City of Albuquerque

April 29, 1992

RE: DRAINAGE PLAN FOR THE PET DOCTOR (C-12/D3B2) ENGINEER'S STAMP DATED APRIL 2, 1992

SECTION A-A
1" = 10' 0"

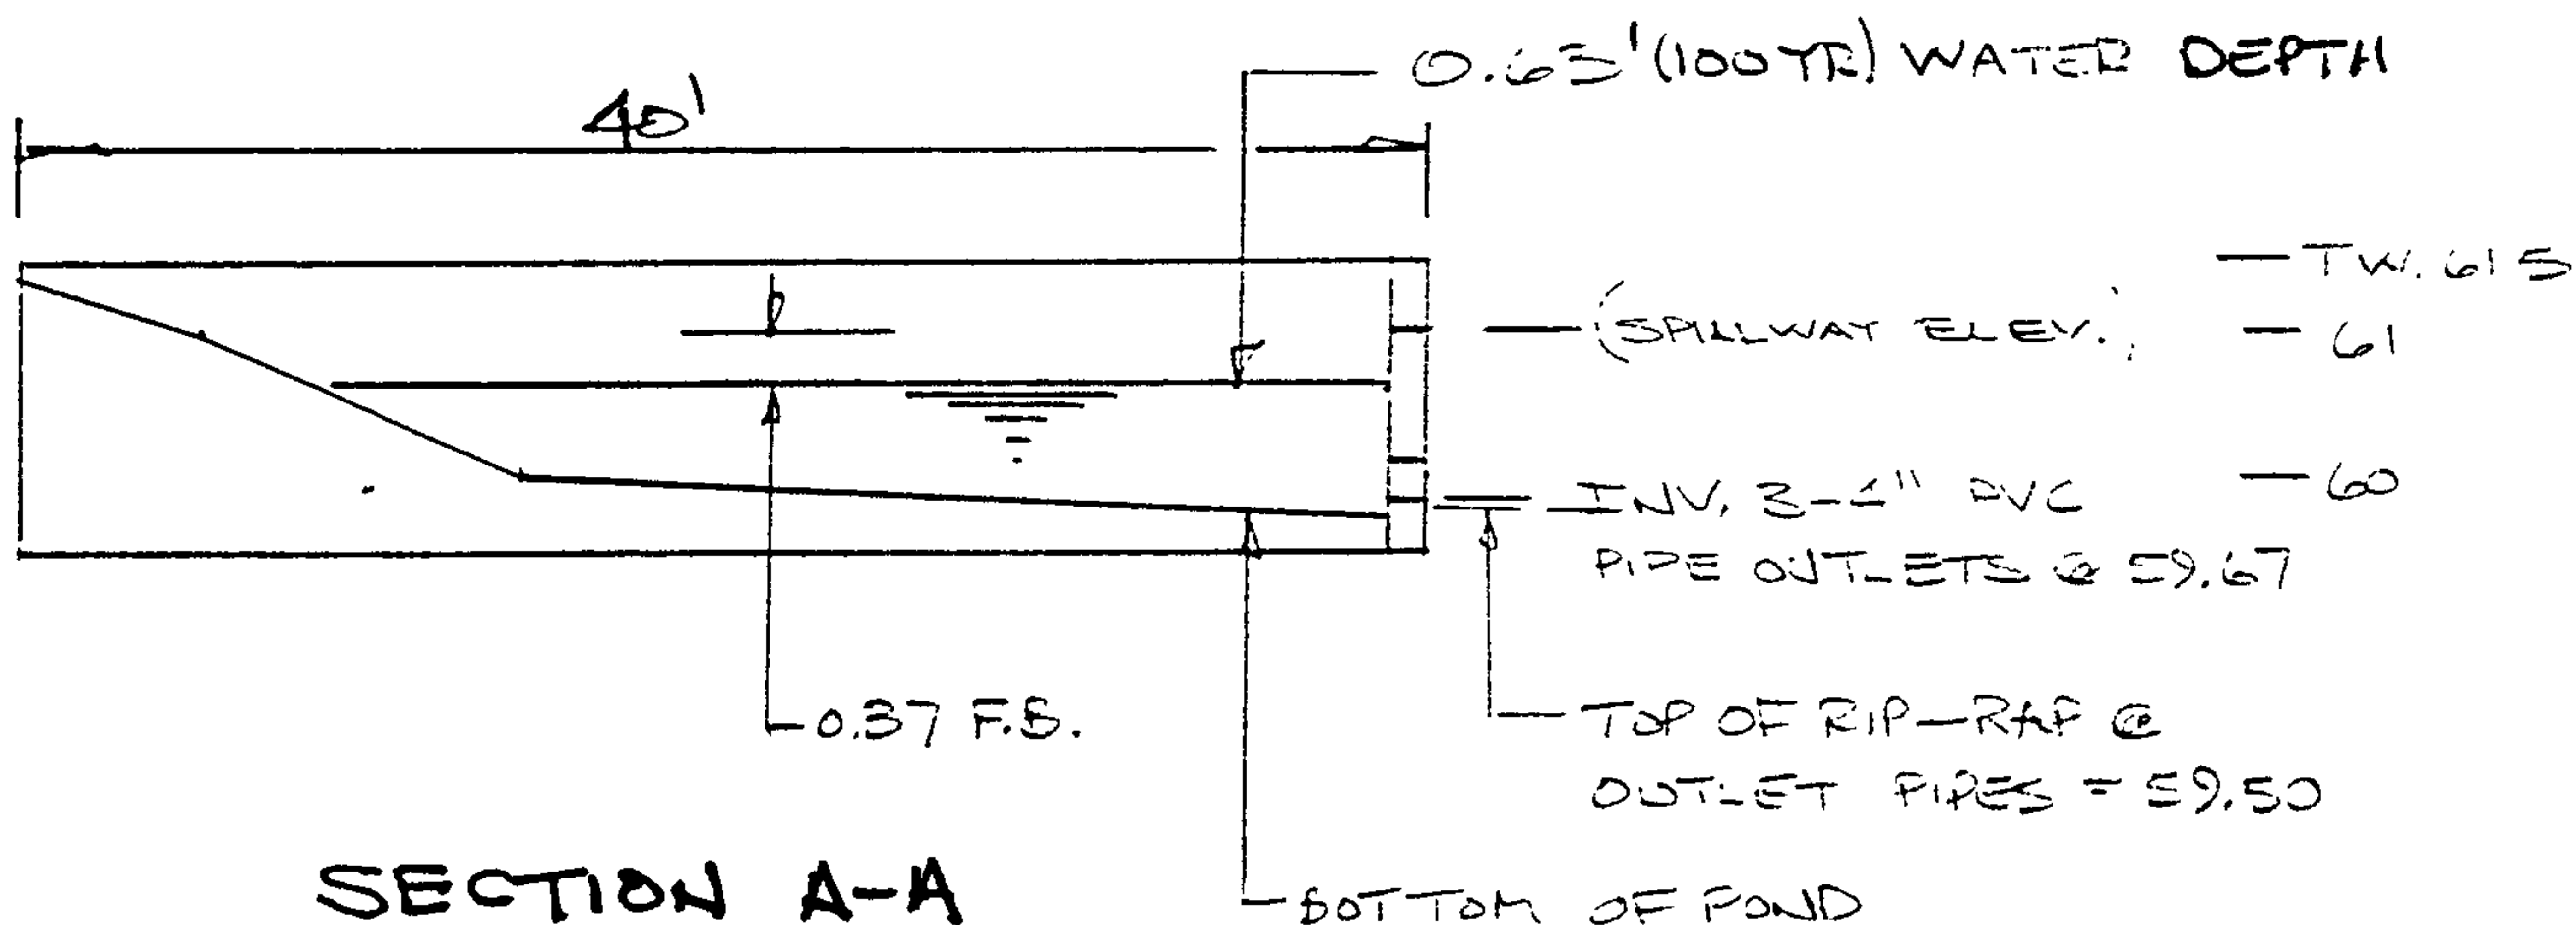
1. HYDRAULICS FOR 3-4" PVC PIPES. YOU ARE ALLOWED TO DISCHARGE ONLY 1.67 CFS" APR 2 1992

2. TYPICAL POND SECTIONS INCLUDES SPOT ELEVATIONS AND THE 100 YR. WATER SURFACE ELEVATION.
 (SEE ATTACHED DRAWING)

3. INCLUDE THE CALCULATIONS FOR THE EMERGENCY SPILLWAY.

SOLUTION: SOLVE FOR SINGLE 4" ϕ PIPE WHERE
 $Q = \frac{1.67 \text{ CFS}}{3} = 0.56 \text{ CFS}$

SELECT AN OUTFLOW PIPE FROM THE ORIFICE FORMULA THAT WILL YIELD THE ALLOWABLE OUTFLOW OF $> 0.56 \text{ CFS}$ UNDER A HEAD OF 1.0 FEET.

$$Q = C A \sqrt{2 g H} \quad \text{WHERE } C = 0.80 \text{ FROM TABLE 4-10, HANDBOOK OF HYDRAULICS KING AND FRATER, 1962}$$

$$A = \frac{Q}{C \sqrt{2 g H}} = \frac{0.56}{0.80 \sqrt{2(32.2)(1.0)}} = 0.087 \text{ FT}^2$$

3 PIPE WILL THEREFORE RELEASE
 $3 \times 0.56 \text{ CFS} = 1.67 \text{ CFS}$
 UNDER ONE FOOT OF HEAD.

SOLUTION: SOLVING FOR A 'BRIDG CRESTED WEIR' DUE TO THE MINIMAL DEPTH.

$$Q = C B H^{3/2} \quad \text{WHERE } C = 2.7, B = 4', H = 0.30'$$

$$= 1.77 > 1.67 (\text{TOTAL } Q_{100}) = \text{O.K.}$$
